KITITAS COUNTY

MEMORANDUM

TO: All Staff
FROM: Public Works Plan Review Team
DATE: February 18, 2026
SUBJECT: VA-26-00001 Regan

Regan, Tracy
1011 Sky Meadows Dr., Cle Elum, WA
Parcel ID: 116734
Map #: 19-16-17050-0003

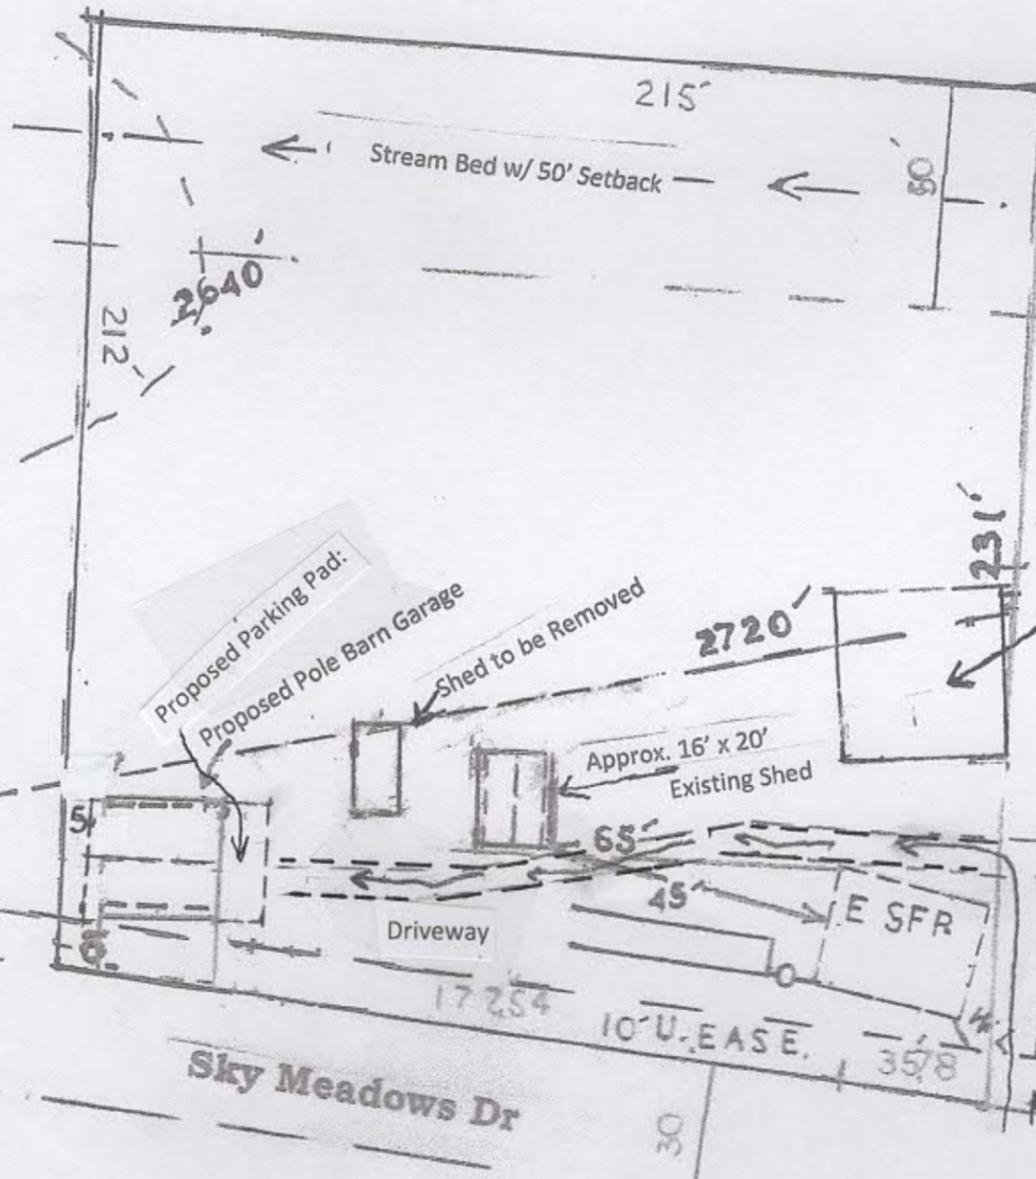
ACCESS	<ol style="list-style-type: none"> 1. An approved access permit shall be required from the Kittitas County Department of Public Works prior to creating any new driveway access or altering an existing access. 2. Maintenance of driveway approaches shall be the responsibility of the owner whose property they serve. The County will not maintain accesses. 3. Residential construction on this parcel would require the roads leading to this parcel to be certified by a licensed engineer. The road would need to be certified up to the point of an approved fire apparatus turnaround. A road certification permit would be required from Public Works. <p>In addition to the above-mentioned conditions, all applicable Kittitas County Road Standards apply to this proposal. Access is not guaranteed to any existing or created parcel on this application. (RC)</p>
ENGINEERING	Except as exempted in KCC 14.05.060, no grading or filling upon a site involving more than one hundred (100) cubic yards shall be performed without a grading permit from the County Engineer or Public Works designee (KCC 14.05.050). An application for grading in excess of five hundred (500) cubic yards shall be accompanied by an engineered grading plan (KCC 14.05.080). (CP)

SURVEY	Due to the minimal requested setbacks, it is highly recommended that the building envelope be staked by a professional land surveyor. (JT)
TRANSPORTATION CONCURRENCY	No Comment. (RC)
FLOOD	Parcel #116734 is not within a FEMA identified special flood hazard area (1 percent annual chance flood zone). A floodplain development permit is not required. (SC)
WATER MITIGATION/ METERING	No comments. (SC)
AIRPORT	No Comment. (RC)
